PROPOSED IMPROVEMENTS TO THE ACCESS AND FOOTWAYS
KINGS CLOSE YAPTON WEST SUSSEX

STAGE 1 ROAD SAFETY AUDIT
DESIGN RESPONSE

DESIGN RESPONSE TO STAGE 1 ROAD SAFETY AUDIT DATED JUNE 2014
CONDUCTED BY LAURENCE SHAW ASSOCIATES. Ref LSA/SA/14/01

drawing no. 13020-03

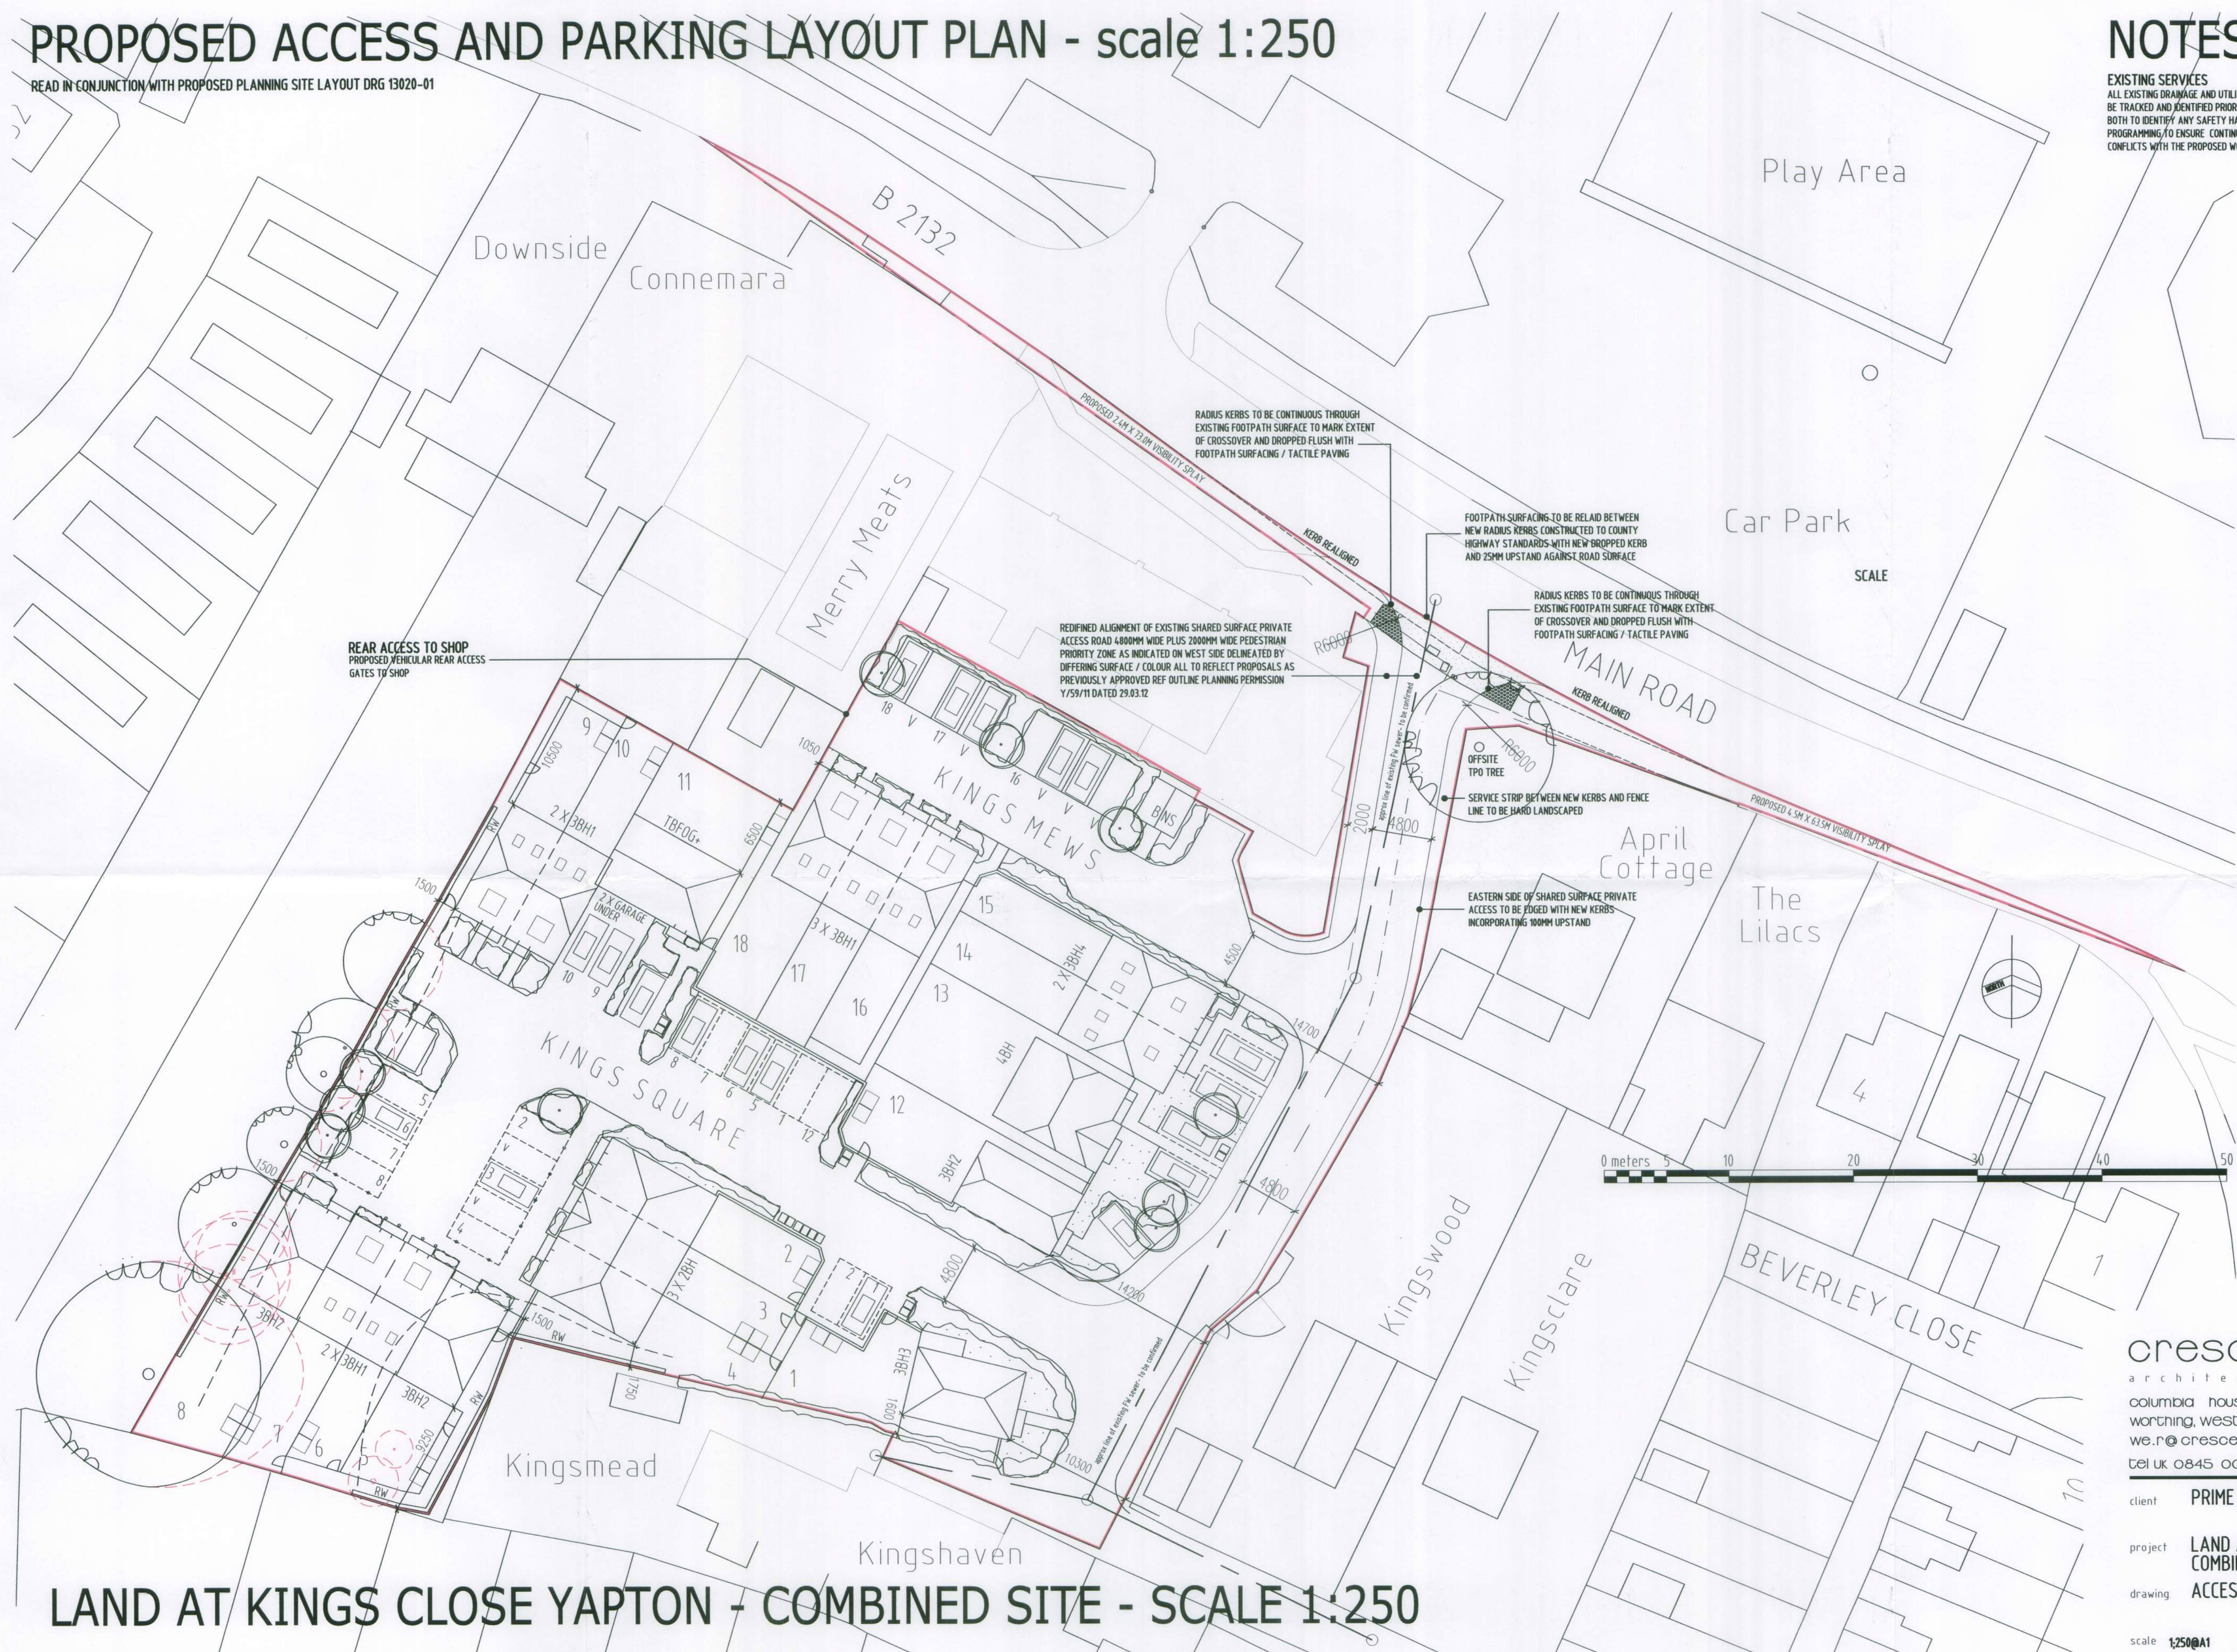
2.2 Problem

Location: At the entrance to Kings Close

Summary: lack of definition of the service margin may result in accidents

Drawing No. 13020-03 shows a 2.0m wide service margin with a footway surface extended from the public highway for a short distance to meet the low level ground cover of the service margin. It is not clear whether the footway surface is level to the shared use area of Kings Close or level to the public highway footway. If the footway surface is at the same level of the Kings Close shared use surface blind of partially sighted pedestrians may become disoriented and pedestrian/vehicle conflicts may occur.

It is recommended that level differences should be provided to the standards of the Inclusive Mobility Unit to assist blind pedestrians.

The short length of footway surface referred to within the audit document is intended as a service margin / raised pedestrian walkway as part of the private road extended from the convenience store forecourt area both raised and distinct in colour from the shared surface itself.

Following a review of the recent coop extension on site the walkway area adjacent the shared surface at the access has been extended in context with the adjacent building slightly further into the site. The outline planning application drawings have been revised noting that a level differentiation is to be included as recommended in the stage 1 audit together with a visual distinction between the walkway, the shared surface and other carriageway surfaces. A larger rumble strip has also been indicated to mark the change of circumstances to drivers at the crossover.

drg no 13020-02REV B scale 1:250 @ A3

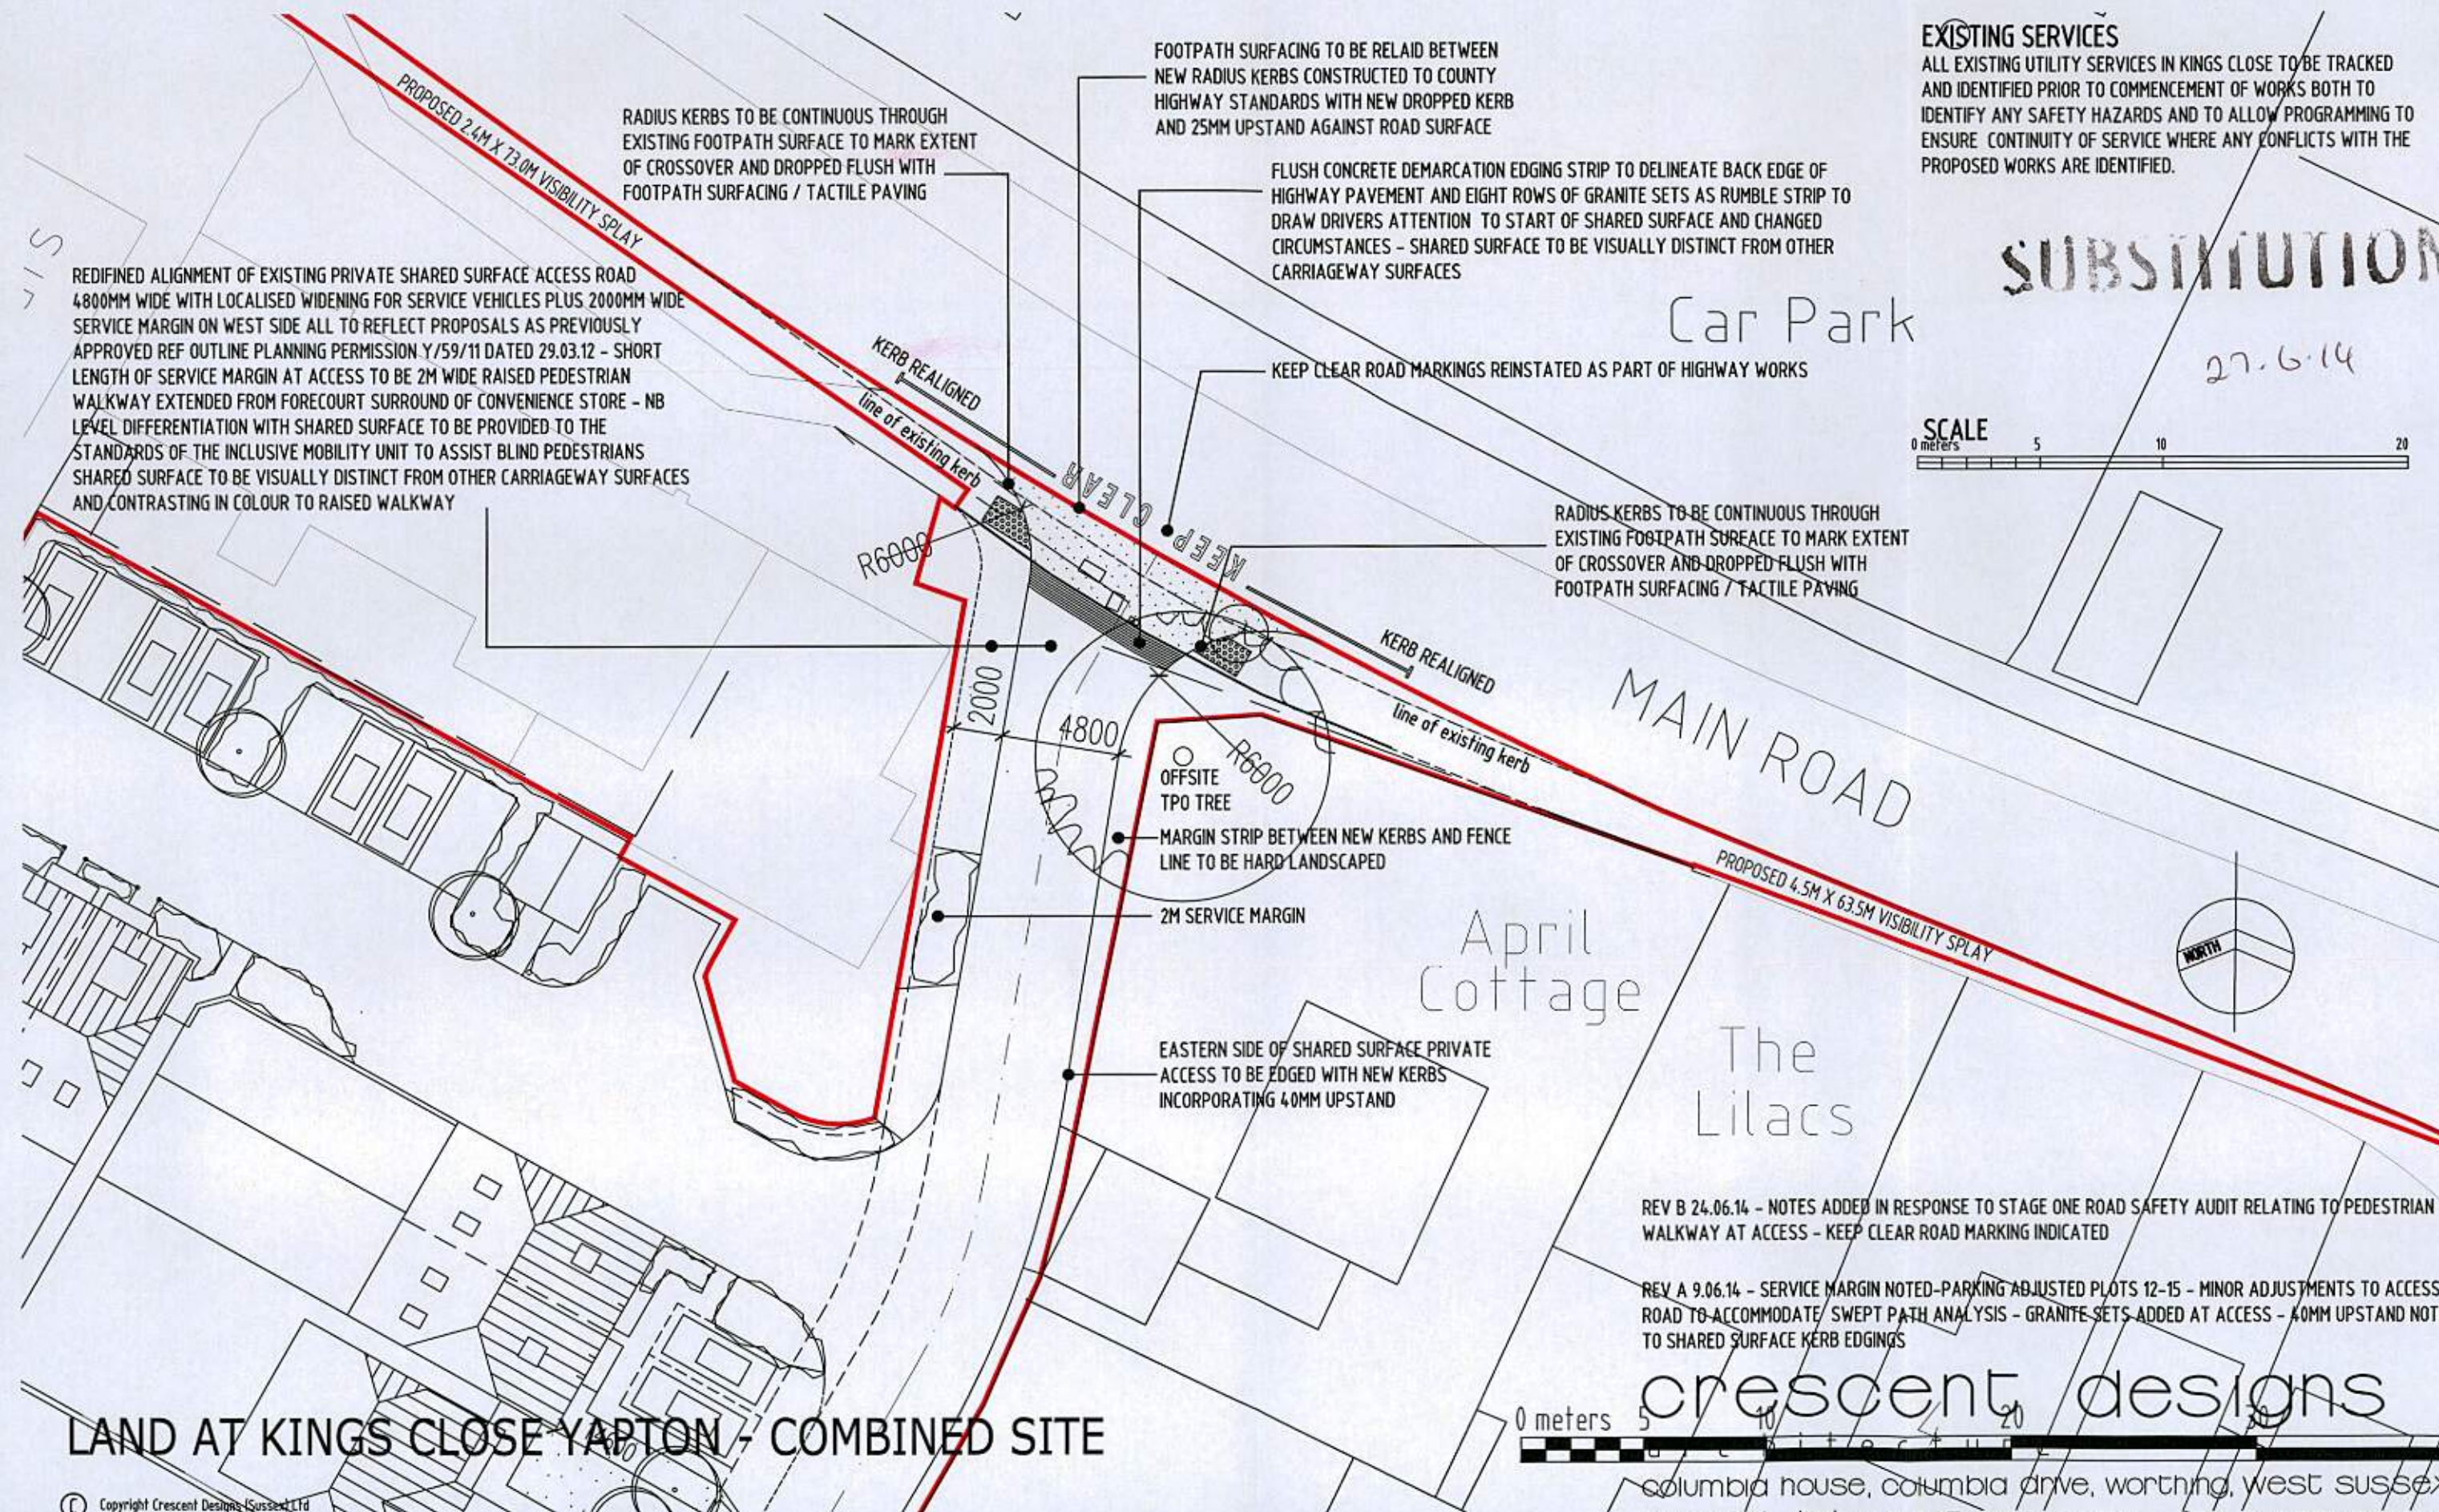
2.1 Problem

Location: At the Main Road/Kings Close junction

Summary: lack of loading facilities may result in accidents

At present it is not clear how the Co-operative Store is serviced, although 'Keep Clear' carriageway markings are across the junction of Kings Close and it is assumed that HGVs are parked on the carriageway of Main Road, possibly across Kings Close while delivering. The reduction of the width of Main Road would present a danger for other road users if HGVs stood on the public highway and may result in vehicle/vehicle conflicts

It is recommended that the loading arrangements at the junction of Main Road/Kings Close are reviewed.

Servicing and deliveries to the convenience store are an ongoing and existing highway management matter.

Maintaining the "keep clear" carriageway markings at the entrance to Kings Close and the presence of the parking layby to the west would suggest a deterrent to HGV's parking on the carriageway in the immediate vicinity of the junction of Kings Close with Main Road.

The outline planning application drawings have been revised to indicate that the "keep clear" road markings at the access to Kings Close are maintained as part of the highway works.
